**WEST SUSSEX COUNTY COUNCIL
STRATEGIC PLANNING CONSULTATION**

DATE: 14 August 2015

**FROM: Dominic Smith TO: Arun District Council
FAO: Dan McEwan**

SUBJECT: A/23/15/OUT – Hybrid application – Full Planning Permission for a retail unit (Class A1) comprising 1,487sqm (1022sqm ground floor and 465sqm mezzanine) with associated access, car parking, servicing, landscaping & associated works. Outline Planning Permission for a public house (Class A4) comprising 581sqm at ground floor level – This is a Departure from the Development Plan

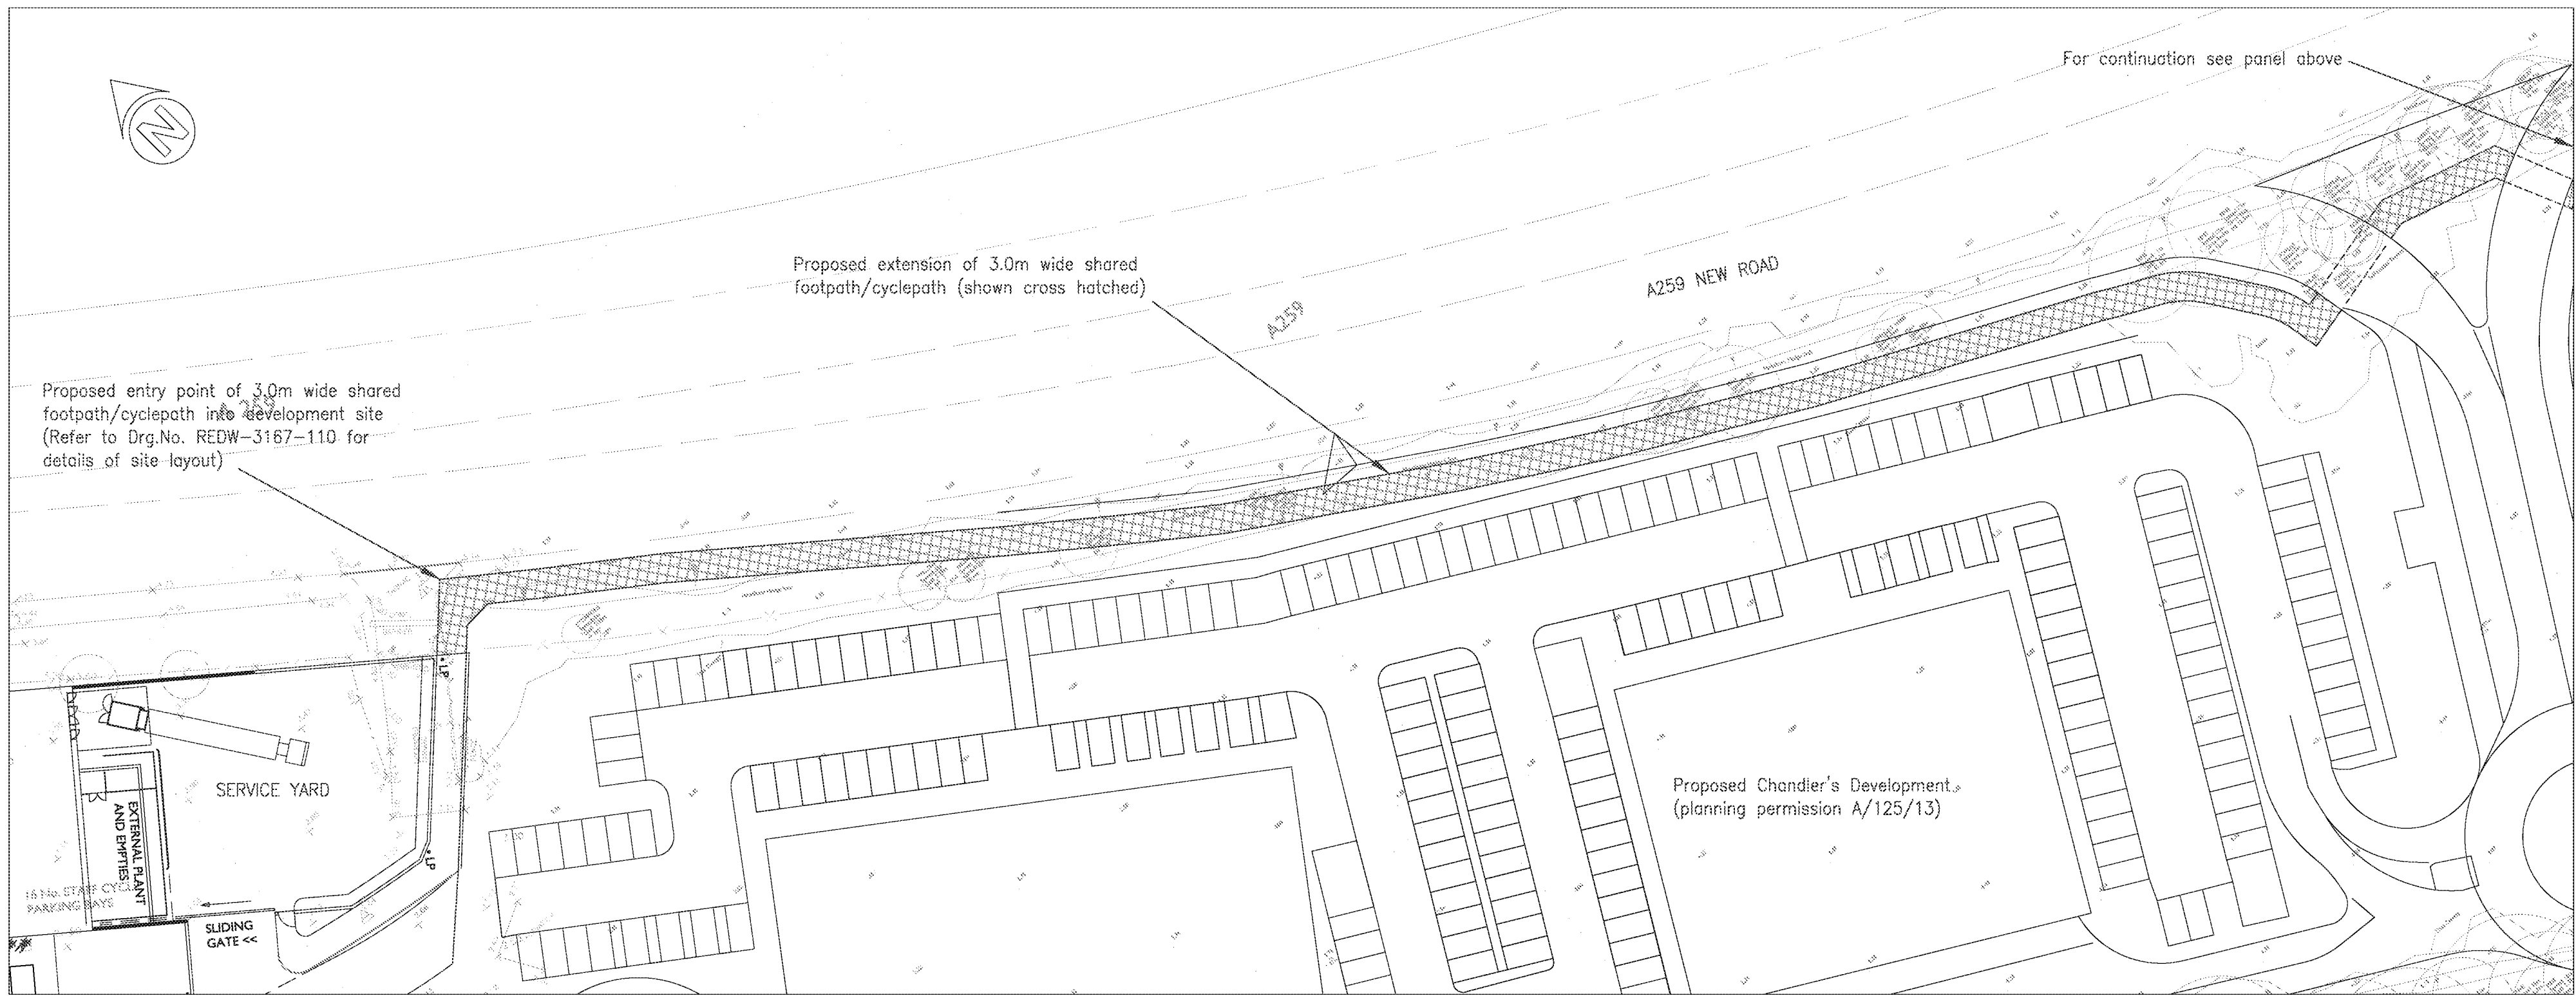
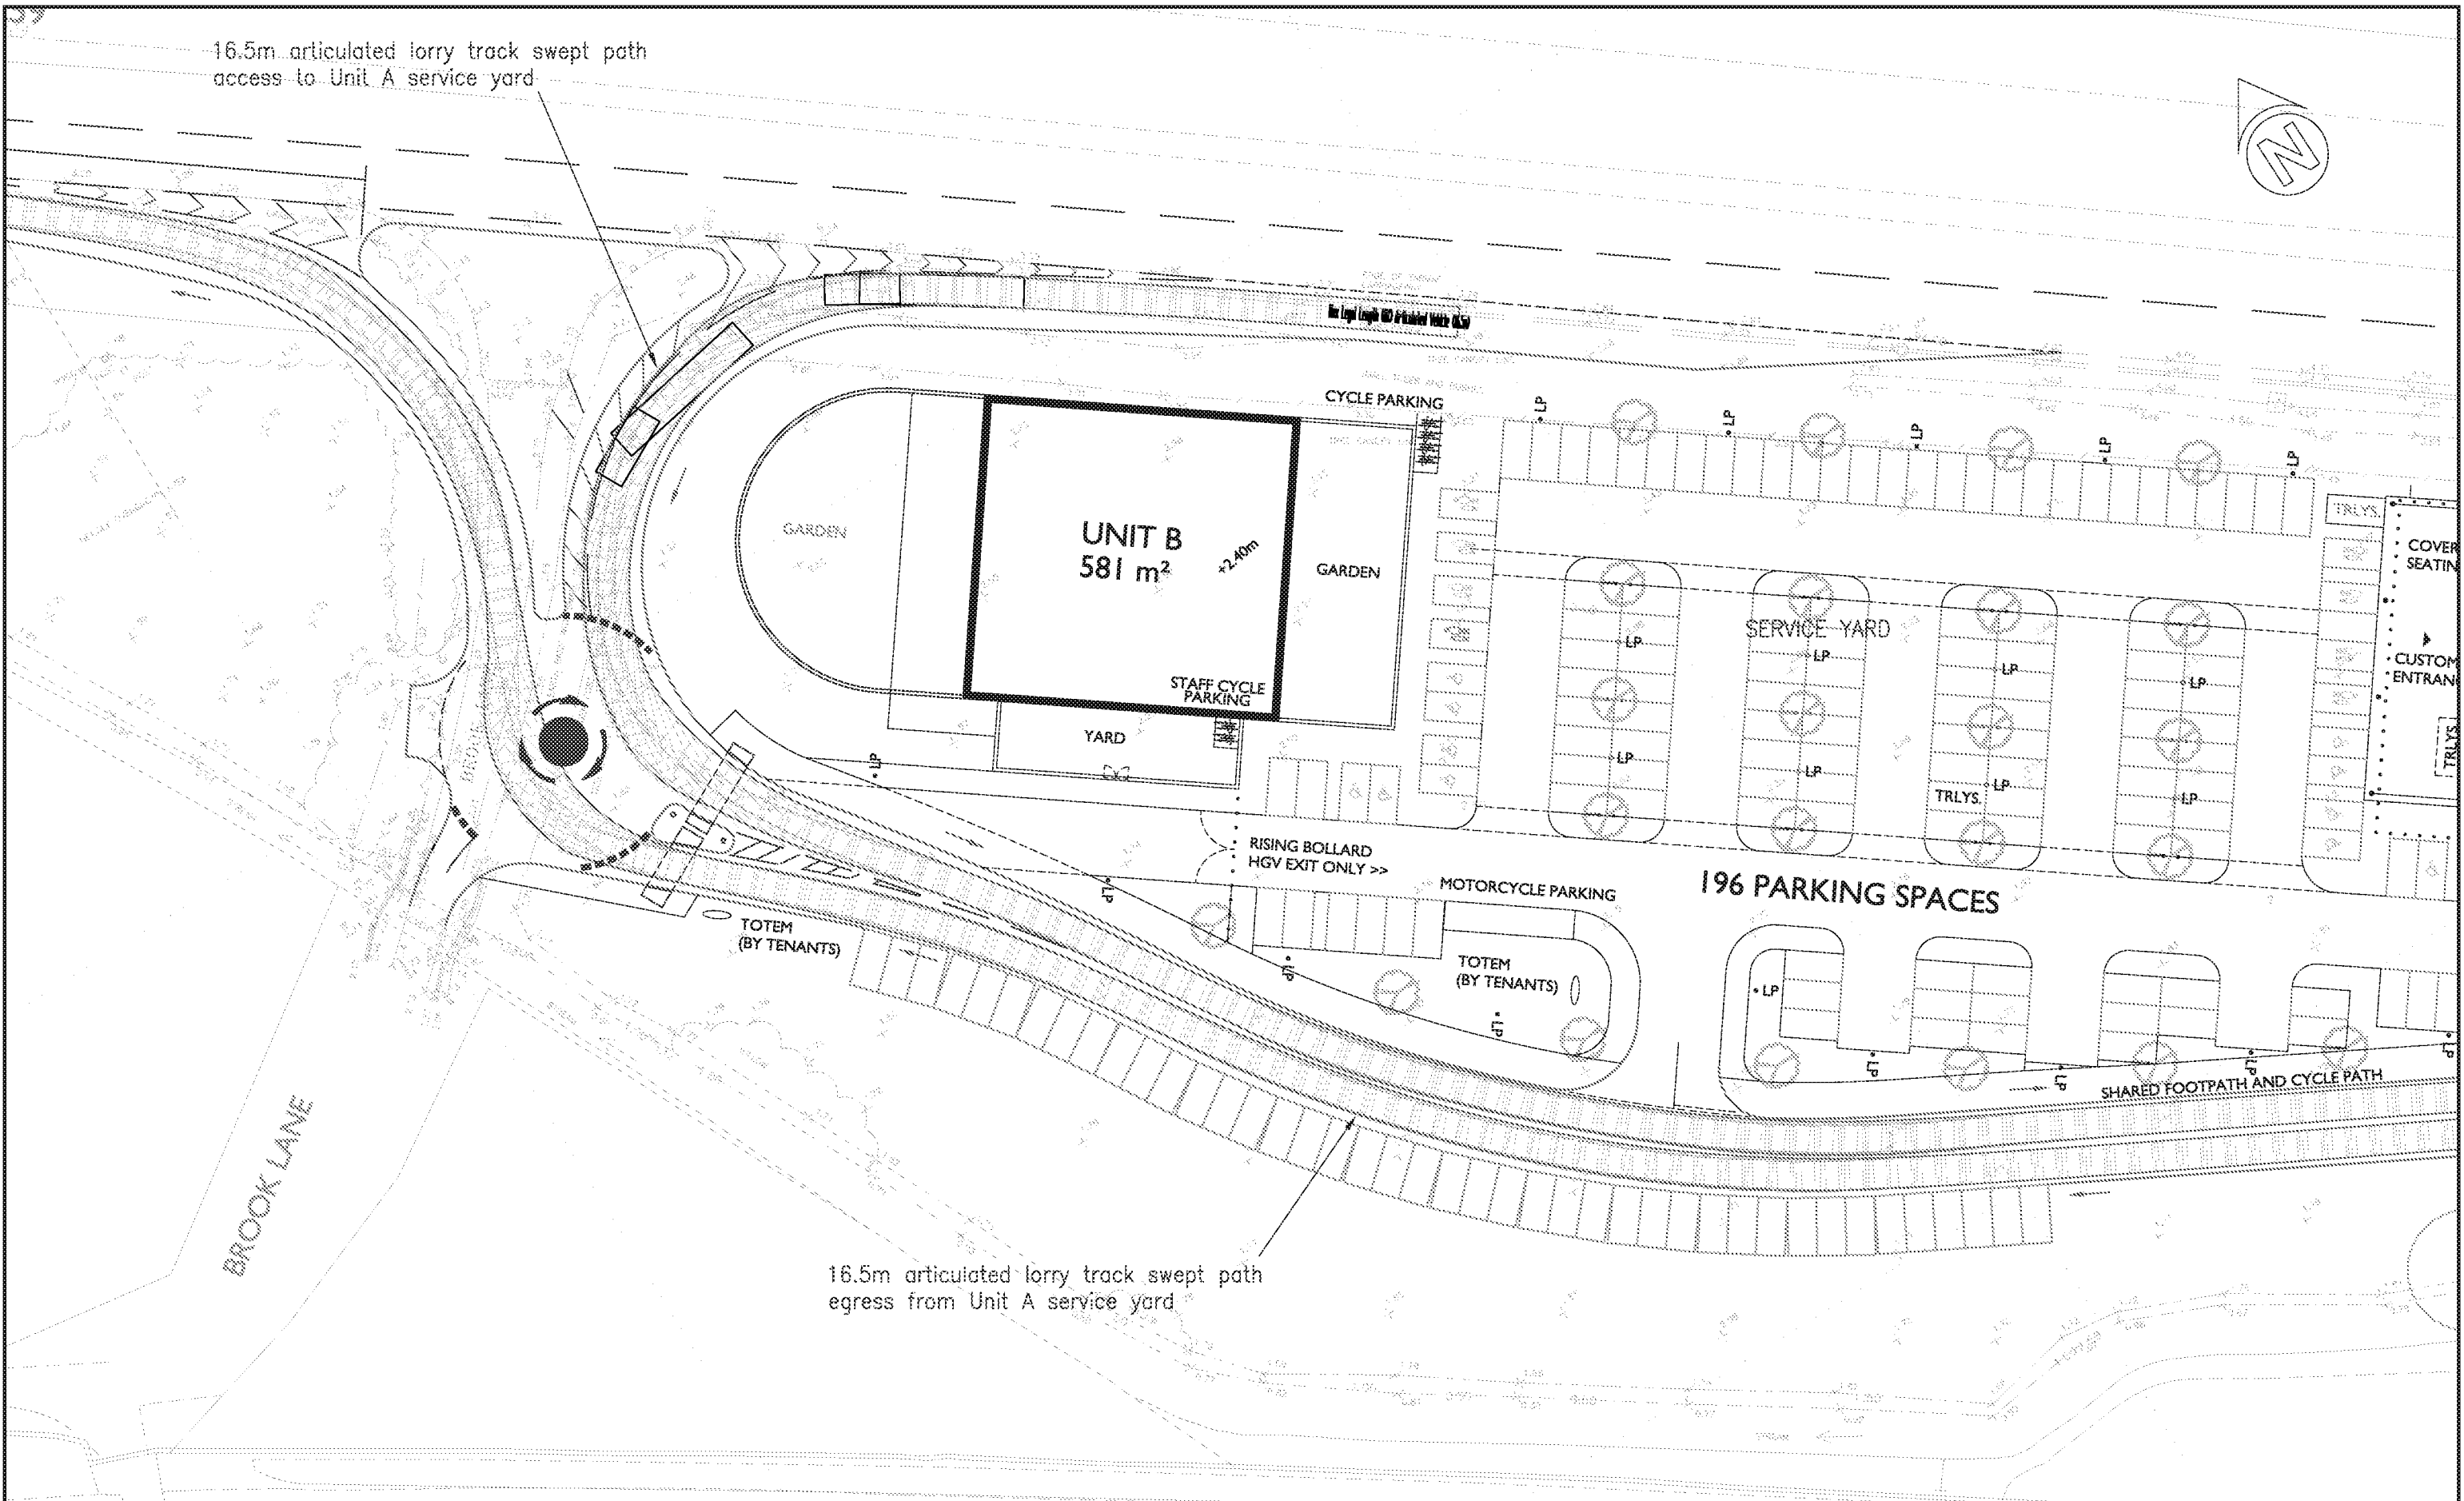
It has now been confirmed that the proposed footway/cycleway extension will measure 3m in width (widening to 3.5m on the bend), and will be located 1.5m from the edge of the A259 in compliance with DMRB TA 90/05 para 7.22. This is shown in drawing no. REDW-3167-111-RevA. Please re-issue this drawing with the highway boundary shown to ensure that it is achievable. In addition, please show the implications for level differences/earthworks and retaining structures, as well as any effect on third party land – this may impact upon the extent of the red line boundary.

Suitable forward visibility of 10m for the design speed of 10kph has been illustrated around the bends adjacent to the service yard in accordance with TA 90/05. Although the design speed should generally be 30kph it is acceptable to have a design speed for 10kph over short distances where cyclists would be expected to slow (i.e. through a bend) with the use of 'SLOW' markings.

Please design the short stub of path to the south of the mini-roundabout to cycleway standards for future connection into the adjacent site.

Title
HIGHWAY ACCESS PLAN

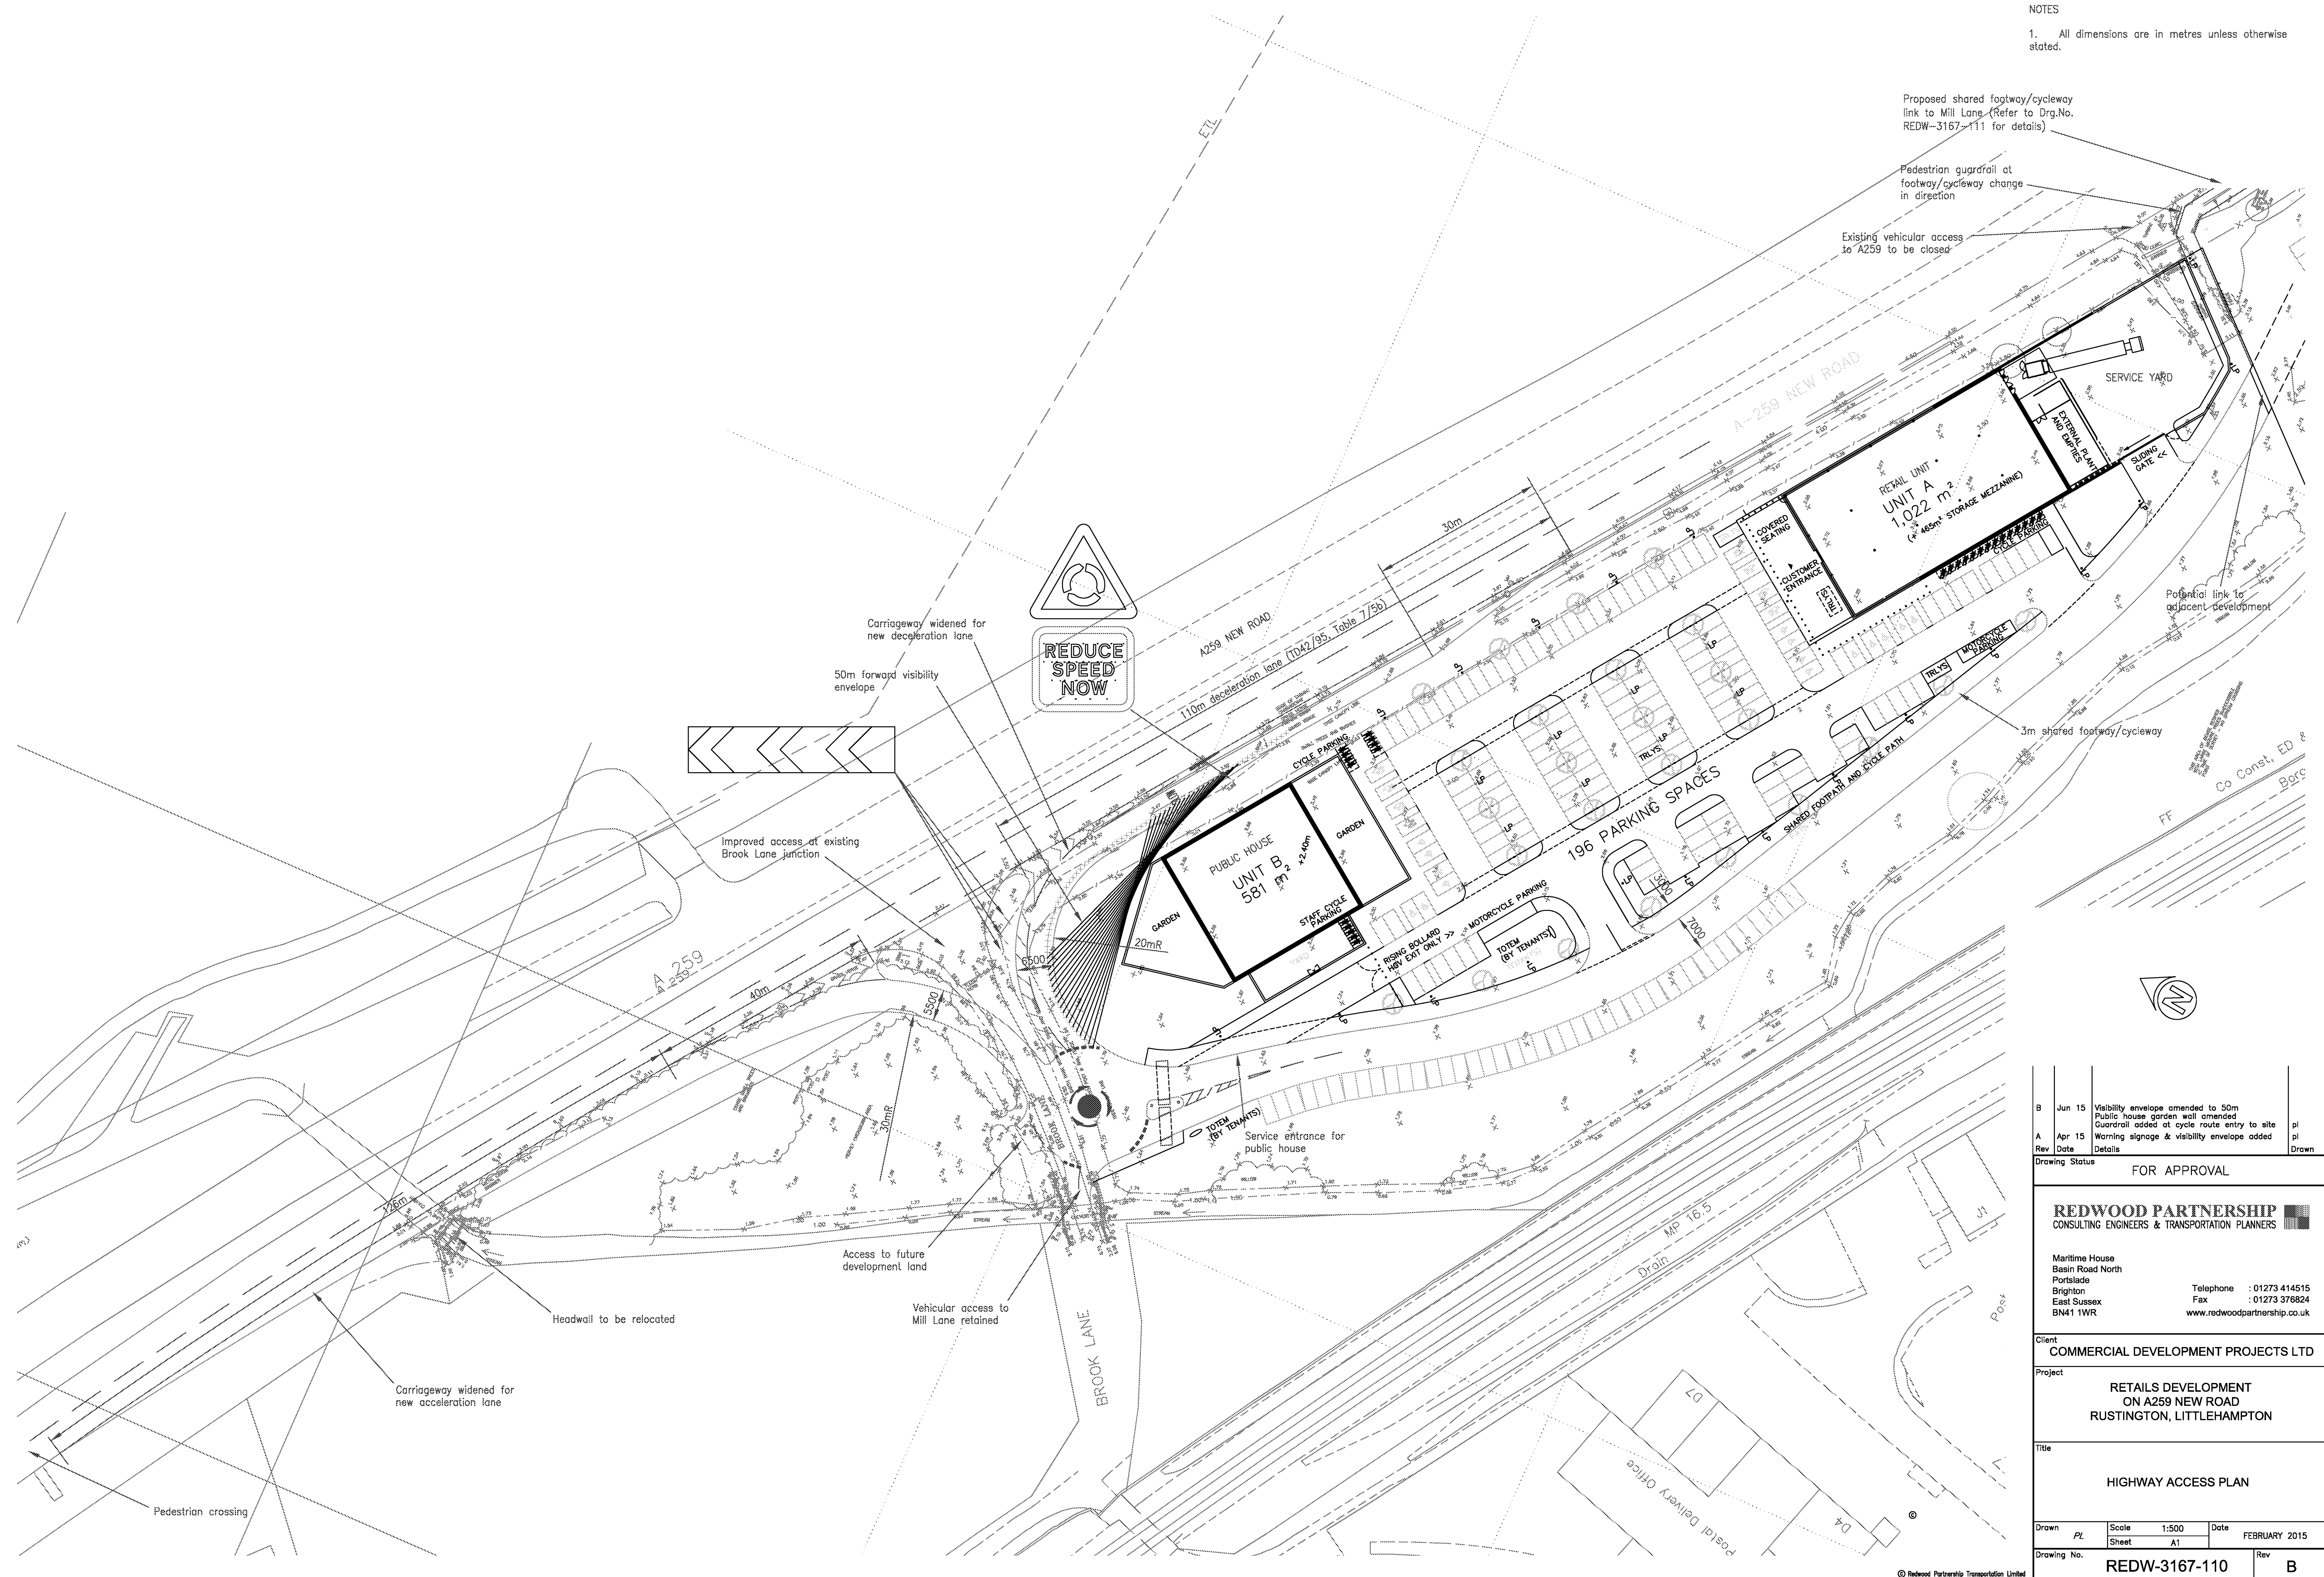
Two Departure from Standard (DfS) applications were submitted in July, in relation to the entry corner radius and the length of the acceleration lane as previously requested. Although these have now both been approved as per the attached documentation, a revision to the design means that the acceleration lane length now meets the required standard. In order to achieve this, the nose ahead of the merging taper that was previously 40m has been reduced to 35m. DMRB TD 42/95 explains that a nose of 40m may precede the merge and it is considered that 35m is therefore acceptable.

In relation to the deceleration lane and diverge DfS, this has been signed off on the basis that a 43m increase in the deceleration lane length is provided to allow a comfortable additional deceleration down before the 20m diverge radii. The need for this extension has been calculated on the basis of the recorded 85th percentile vehicle speeds.

The following comments have been made on the access design which will need to be incorporated at this stage:

- The merge lane alongside the splitter island needs to increase to 6.5m width with hatching by reducing the splitter island slightly to ensure maintenance is possible without closure, and allowed continued operation in the event of a breakdown.
- Please show the forward visibility splay alongside the splitter island on the merge
- It is felt that Brook Lane arm of the mini-roundabout could be better served as a crossover. This would then mean the roundabout would become three arm with the future development site to the west (see below suggestion). If the design does change, the swept path analysis will need to be updated.
- Speed reduction measures should also be considered along the private car park access.

- Consider the need for VRS alongside the development and in the central reservation, including where appropriate a RRRAP.
- Street lighting will need to be provided to achieve a continuously lit road covering the merge manoeuvre and the A259 east of this point to tie in to the existing system.

- The roundabout slow down warning sign needs something to show it relates to the side road – e.g. supplementary plate to Diag 573.
- Please show hard strips and edge of road markings on the A259, and adjust the design to tie in, and consider whether to adjust the set-back to the triangular island to aid buildability (working widths, safety zones, maintenance without a road closure).

- Please show the limit of adoption for the access – ideally this will either be immediately south of the triangular splitter island, or should include the mini-roundabout, the pedestrian refuge to the south east and a short

distance of the stub into the future development land (to be agreed at S38 stage). The totem sign on the splitter island needs to be outside the area of adoptable highway.
